CITY OF ALBUQUERQUE

April 20, 2012

**Re: Tuan Van Huynh Residence Grading and Drainage Plan
Engineer's Stamp dated 04-13-12 (L-23/D001D)**

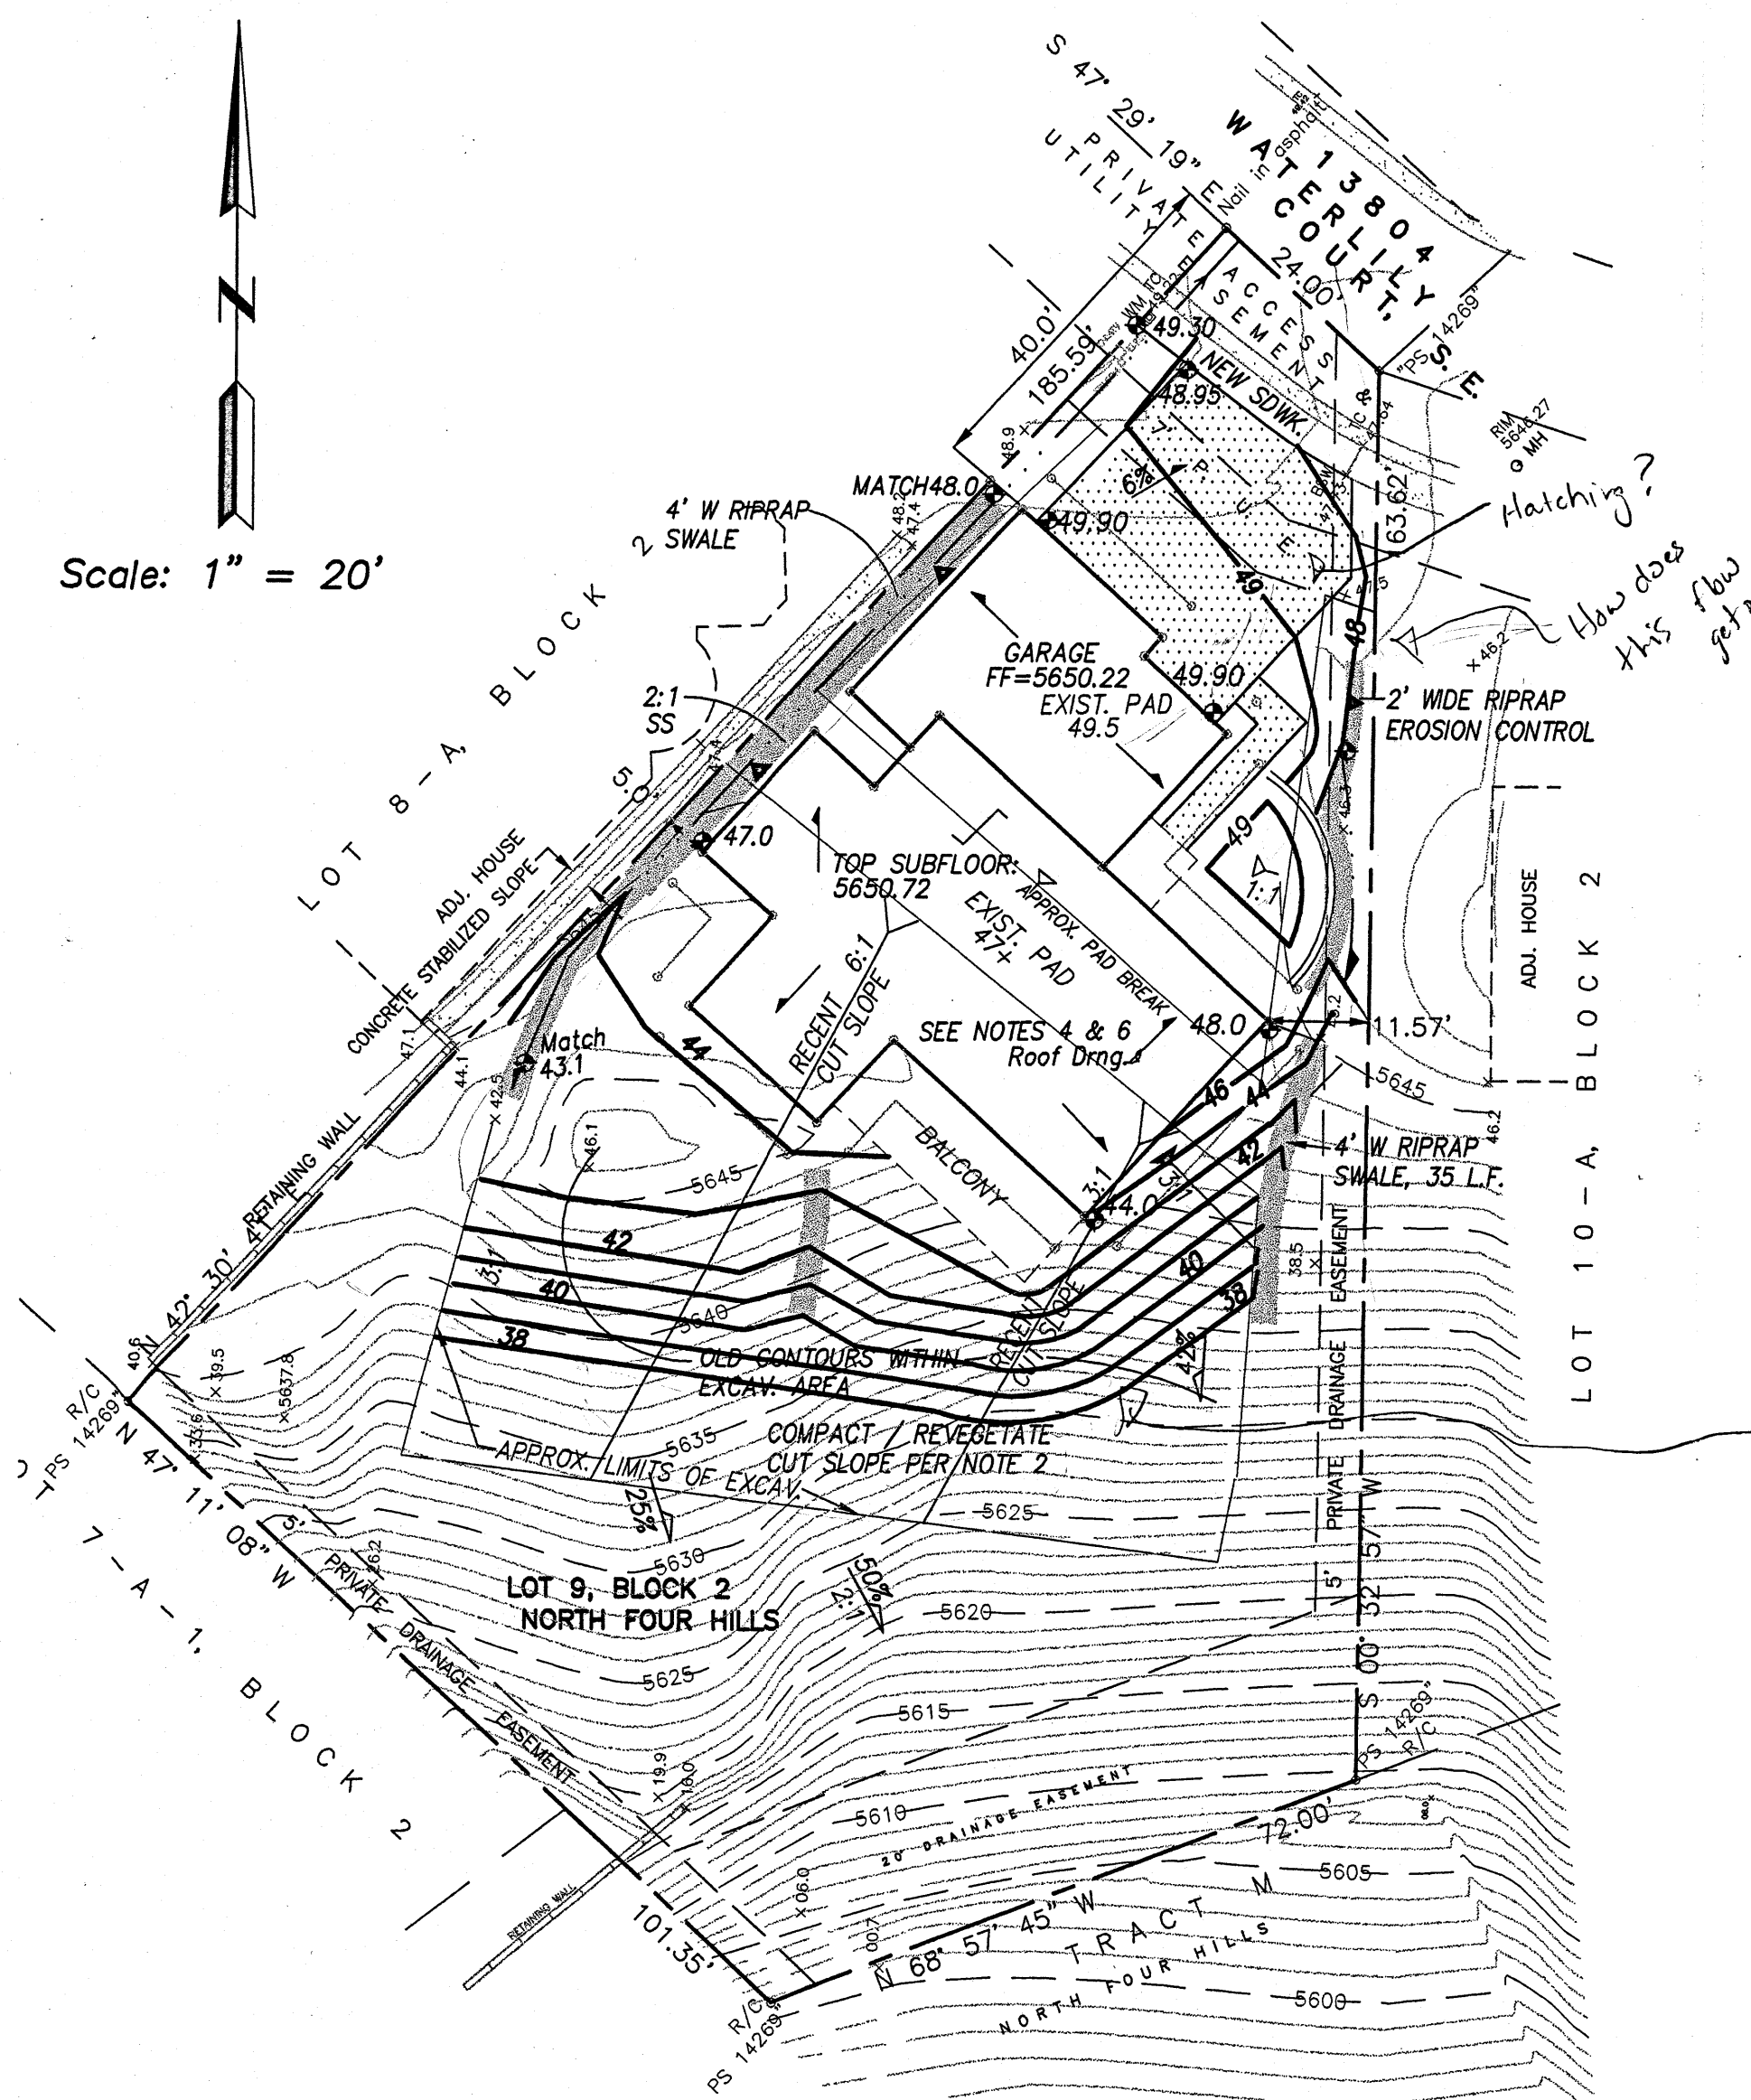
- The 38 ft. contour south of the balcony does not match up with the existing contour of 29 ft. It appears that a retaining wall will be needed along this contour.
- The spot elevation at the southeastern edge of the residence appears to be 3 ft. lower than the existing pad elevation of the home.
- There also appears to be a 4 foot drop around the southeastern edge of the footing for the balcony. How will this be addressed?
